CITY OF ALBUQUERQUE

November 4, 2021

**Re: Westgate Community Center
10001 De Vargas Rd. SW
30-Day Temporary Certificate of Occupancy
Transportation Development Final Inspection
Architect's Stamp dated 12-27-18 (M09D030)
Certification dated 11-3-21**

TRAFFIC CIRCULATION LAYOUT (REVISED)

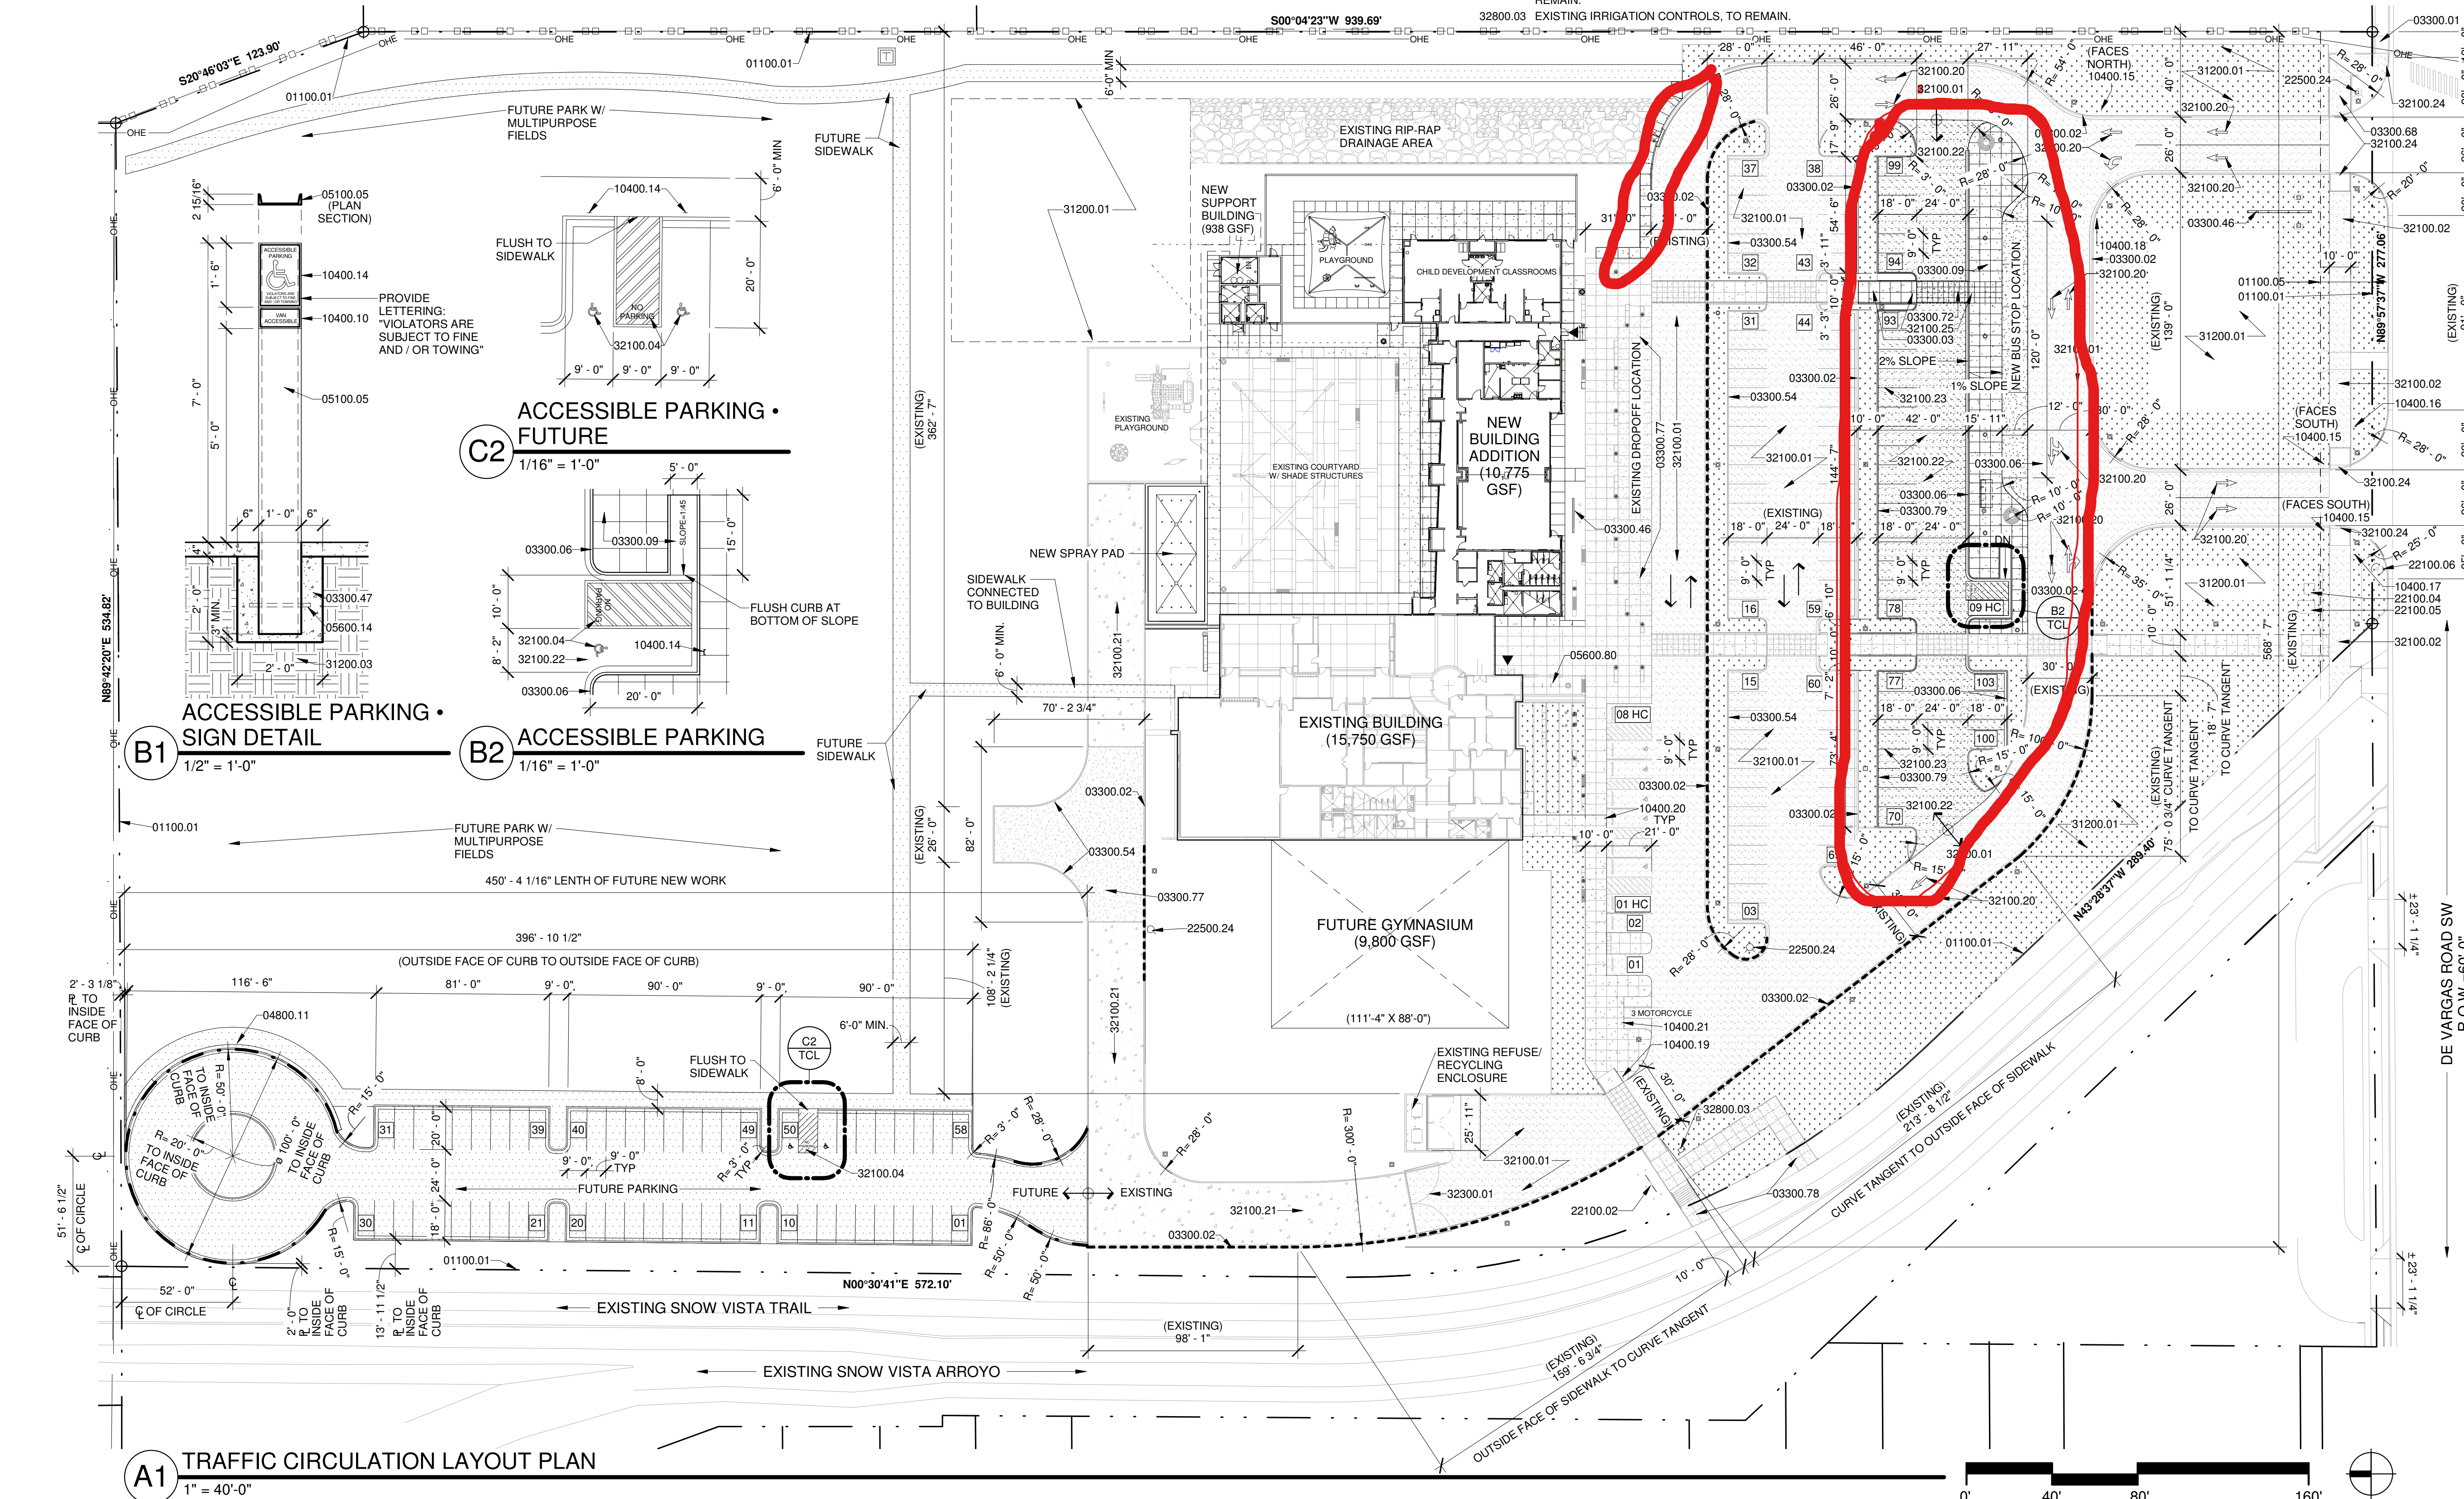
- All Van accessible aisles should be 8ft wide. Please note that you are provided four Van parking spaces, and the required are just two.
- Are you planning to grand open after issued the Temporary Certificate of Occupancy, or after complete building the whole site? Please explain.
- Provide redline approved DRB phase1 site plan.
